Our Ref: BN/92/20/DOC

Approval of details reserved by condition imposed under ref BN/23/15/PL relating to Condition Nos 5 - surface water drainage, 6 - discharge of flows and 7 - future access & maintenance of any watercourse or culvert.

Windermere Lake Lane Barnham PO22 0AD

AS BUILT DRAINAGE

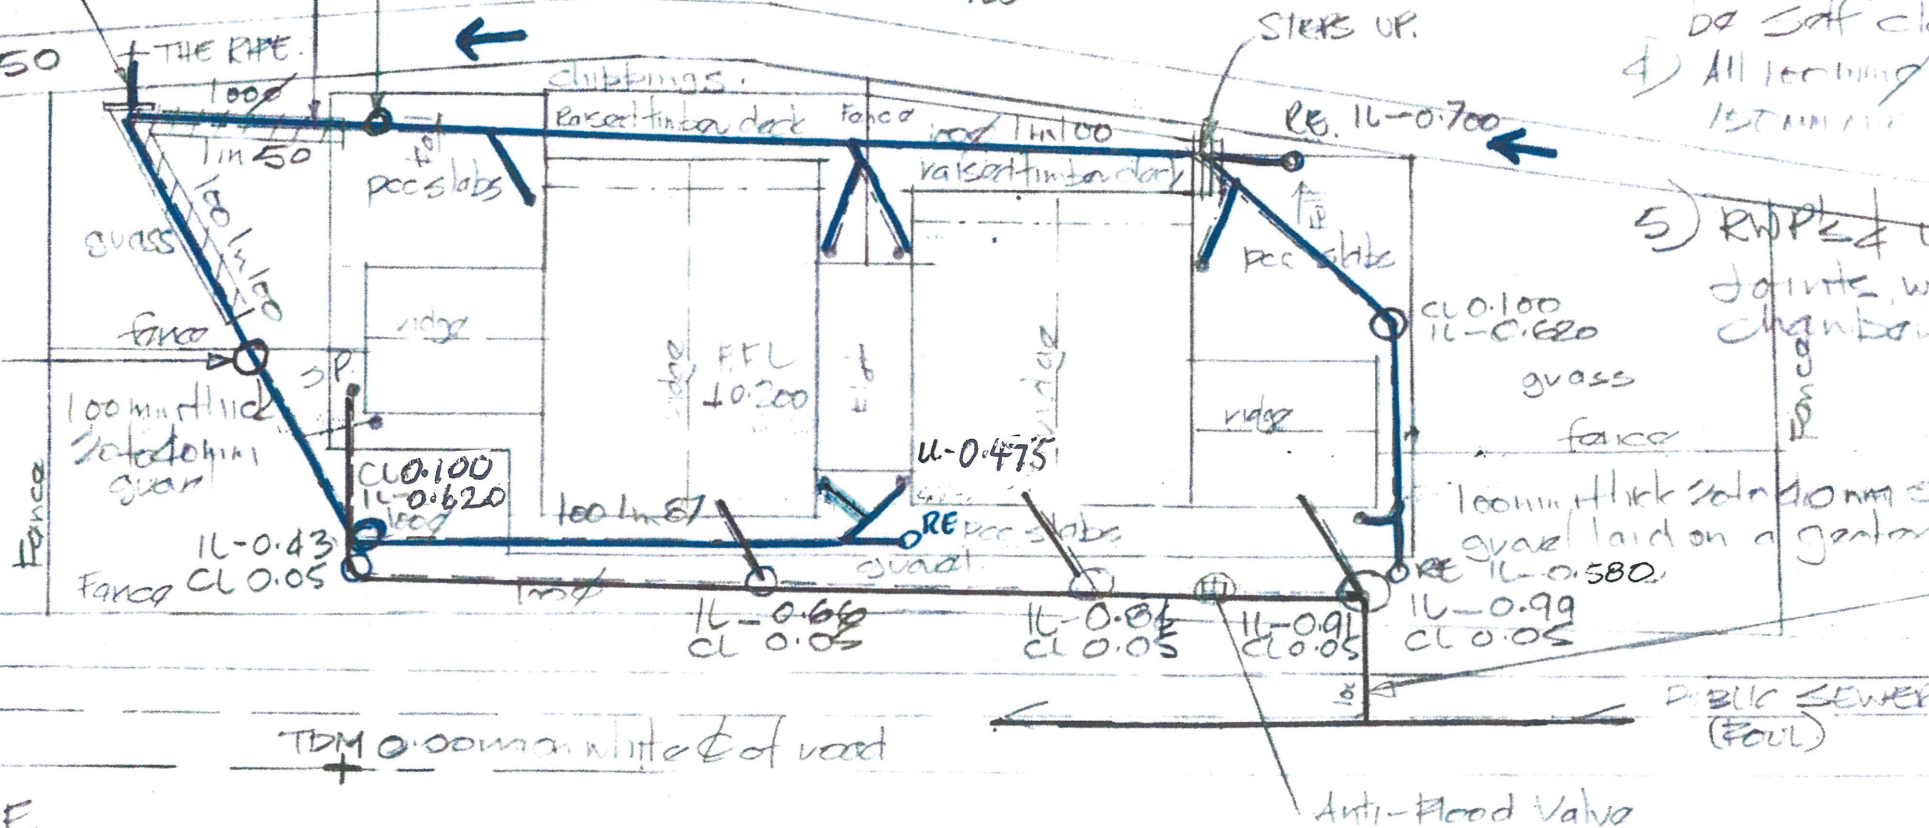
The details submitted in respect of the discharge of any flows to watercourses, or the culverting, diversion, infilling or obstruction of any watercourse on the site, namely the following item have been appraised by the Councils Drainage Engineers, are considered to be acceptable and satisfy the requirements of the condition.

For future reference the agent should note that we normally expect a construction detail drawing for pipe bed and surround, however in this case, due to the scale of the development the noted specification is adequate. On any future applications a drawing will be expected.

The condition is therefore discharged on the understanding that the discharge of any flows to

watercourses, or the culverting, diversion, infilling or obstruction of any watercourse on the site will be implemented in accordance with the approved scheme and permanently retained in good working order thereafter.
